Consultation Response from: KC Environmental Health (Pollution & Noise Control)		
2022/91735 Land off, Hermitage Park, Lepton, Huddersfield, HD8 0JU		
Outline application for erection of 80 dwellings and associated work, including the considerations of access, layout, and landscaping		
Date Responded: 22nd August 2022	Responding Officer: Rebecca Muff – Air Quality Natalie Heaney – Contaminated Land Mohammed Nasim - Noise	Responding Ref: WK/202220362
Air Quality An Air Quality Assessment by SLR (ref: 410.10429.00003) (version: rev 3) (dated: February 2022) has been submitted in support of the application. The proposed development site is situated off Hermitage Park, to the South of Rowley Lane, in Lepton, approximately 3.2 miles to the South-East of Huddersfield. It is not within an Air Quality Management Area (AQMA) or near to any roads of concern. The report details the impact that the development will have on existing air quality, and how this will impact existing and future sensitive receptors during the construction and operational phases. It uses techniques detailed in national and local guidance, such as Local Air Quality Management Technical Guidance (LAQM. TG16), the Instit

Sound map indicating the external daytime $L_{Aeq,16hour}$ environmental sound levels at Ground floor level (2.5m)

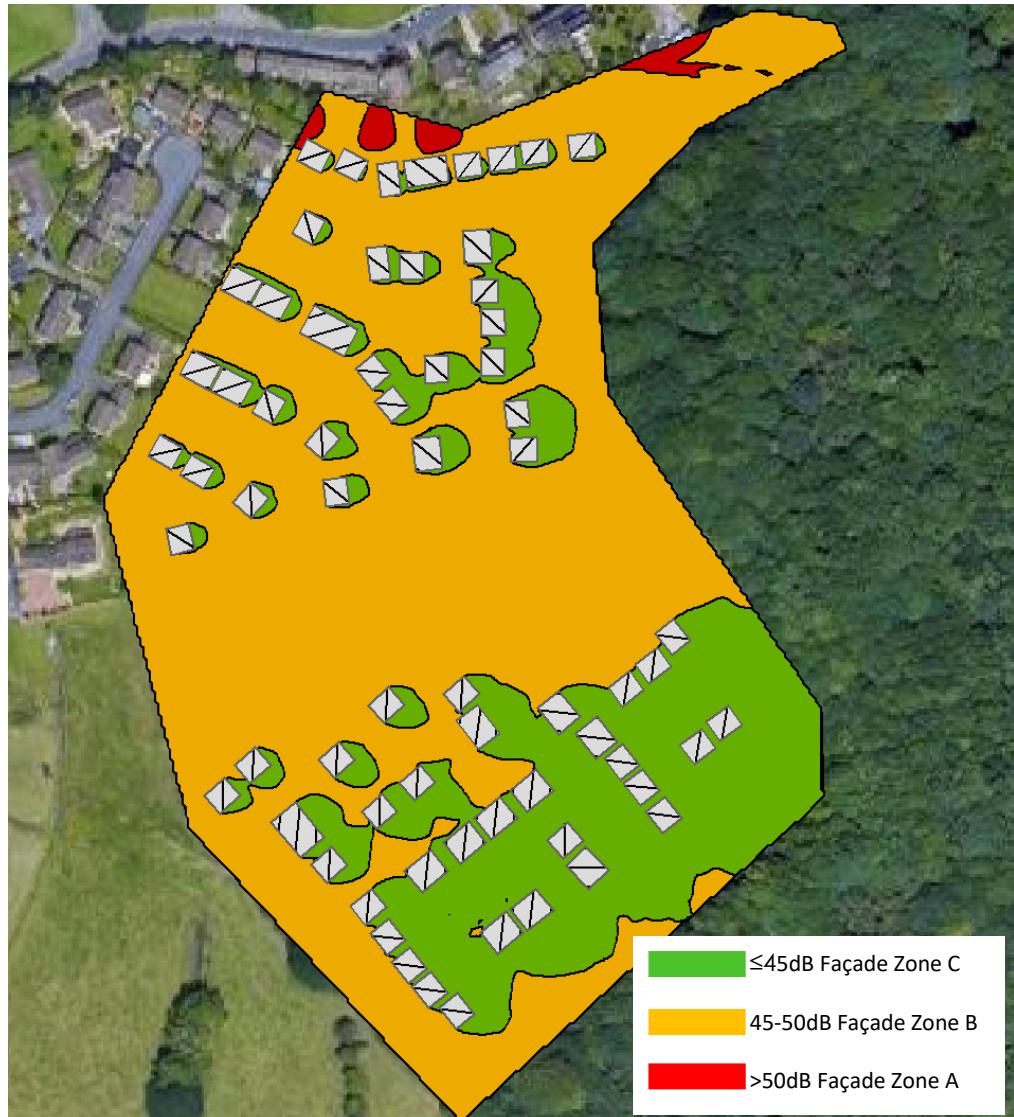
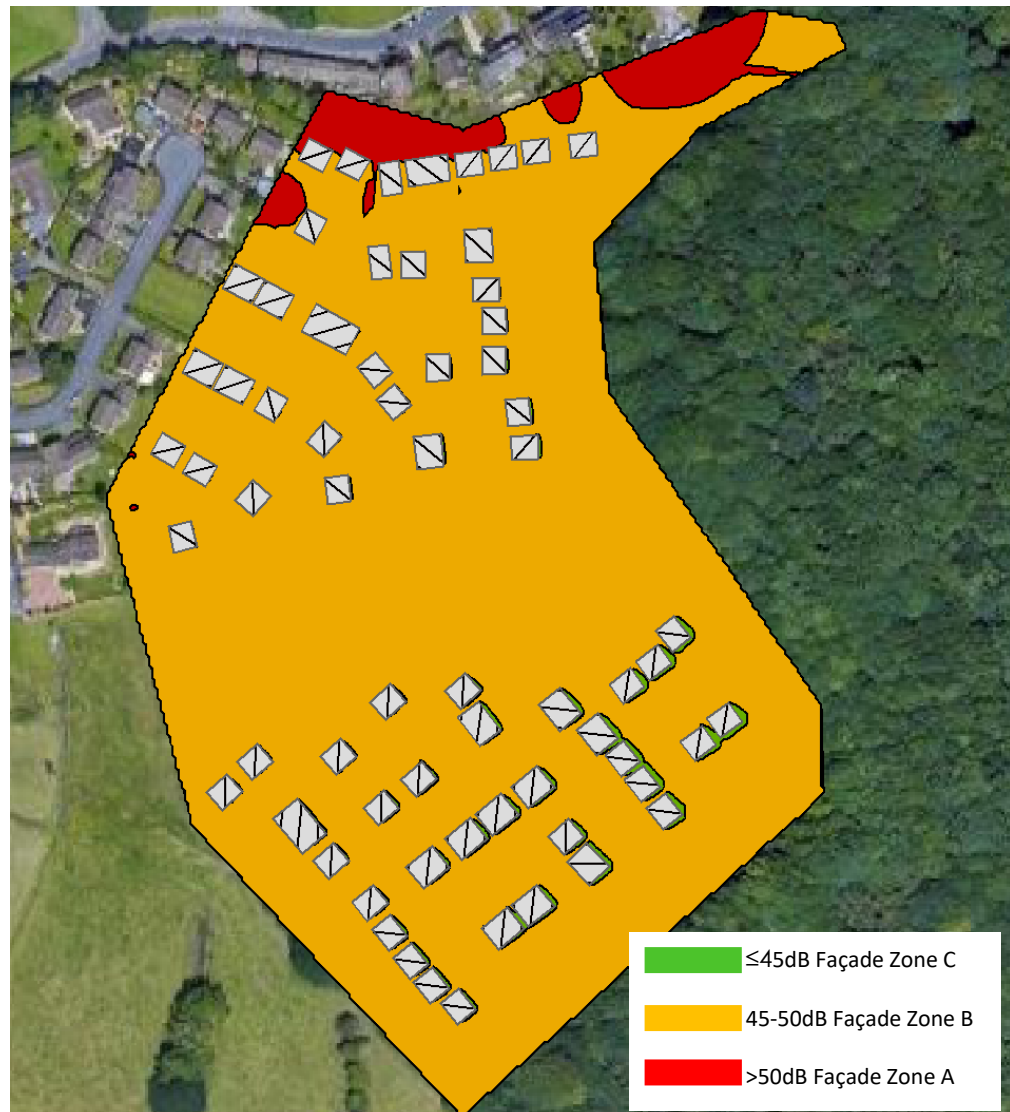
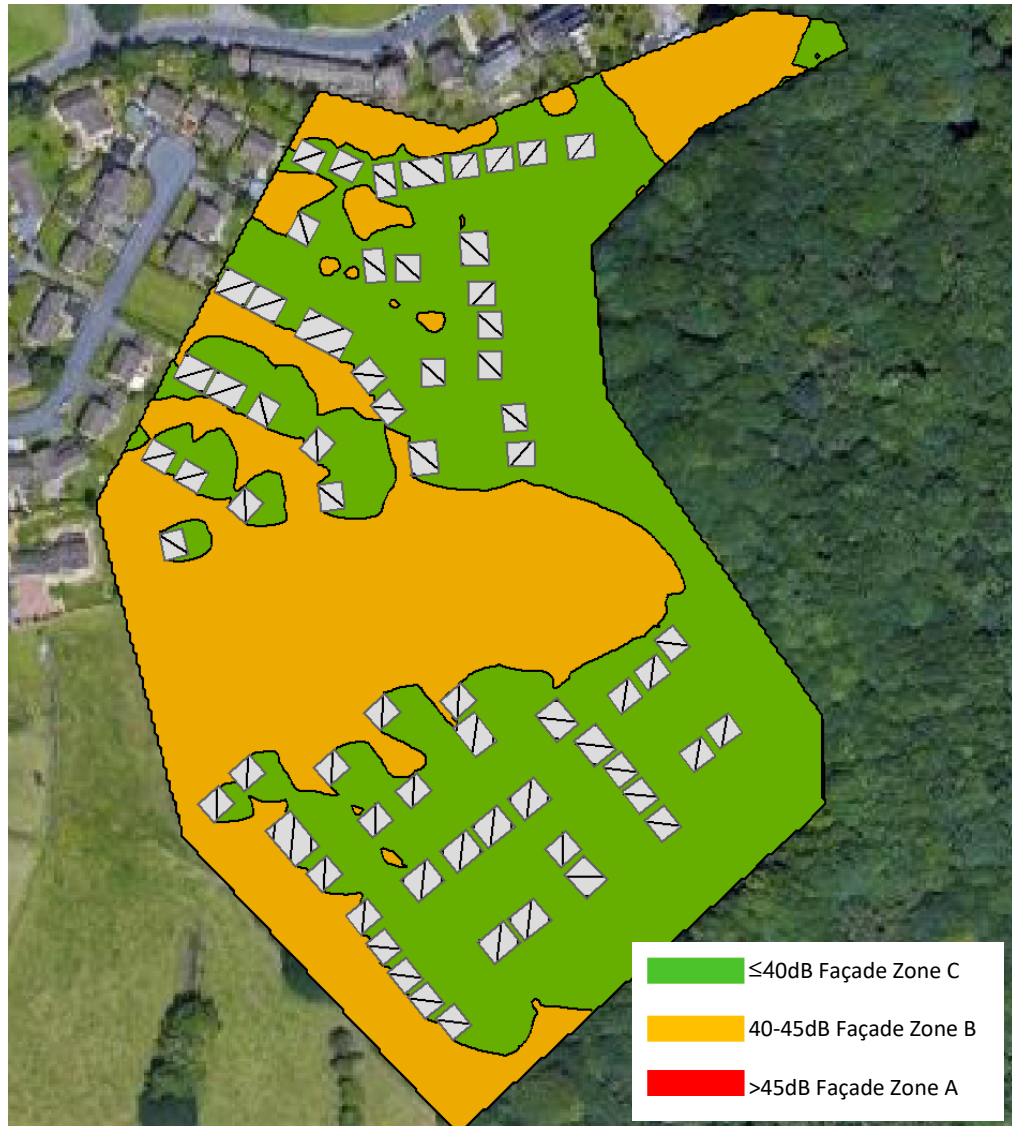
Automated environmental sound measurements were undertaken from 1400hrs on Wednesday 28 September 2020 to 1400hrs on Thursday 29th September 2020 from two measurement locations shown on the site plan. Position A was to the south of the site and position B was to the north of the site. The results are shown in para 5.5.2. The site layout as per drawing number 3284-0-002 from Nieman Architects dated 22nd September 2021 was used for noise modelling and this is shown in para 6.8 for internal daytime requirements and external daytime requirements and para 6.9 for internal night time requirements. The modelling shows parts of the façade in zone A exceed the requirements within BS8233 and mitigation will therefore be required.

Based upon reasonable assumptions for the construction proposals, glazing and ventilation is considered and at para 6.6.1, the report states '*In order to achieve the internal daytime and night-time requirements openable windows must remain closed In Façade Zones A and B*'. The number and technical specifications of the required ventilators is given along with a comment about mechanical ventilation which will be required to provide summer cooling. No detail is given on which system will, be installed.

It is our position that acoustic trickle ventilation alone is unlikely to provide sufficient ventilation i.e. purge ventilation, to help control thermal comfort without the need to open windows and would therefore not be acceptable. It is unacceptable that building occupiers will be faced with the option of having to be exposed to either excessive noise or excessive heat and this is the situation that Kirklees requires to be addressed through the provision of an alternative ventilation system when windows need to be kept closed for noise mitigation reasons.

To assist the applicant, an alternative ventilation system would need to provide a level of ventilation to properties affected by excessive external noise, sufficient to replace the ventilation which would normally be provided by opening windows. Systems that draw in air from the roof-space of the building would need a bypass to allow air from the outside to be drawn in during warm weather.

The alternative ventilation scheme must identify which rooms require a ventilation system and the acoustic specification of the proposed ventilation system demonstrating that when operated it will not cause indoor noise target levels to be exceeded. Also, the alternative ventilation system must not compromise the sound insulation properties of the building envelope. A condition is recommended.
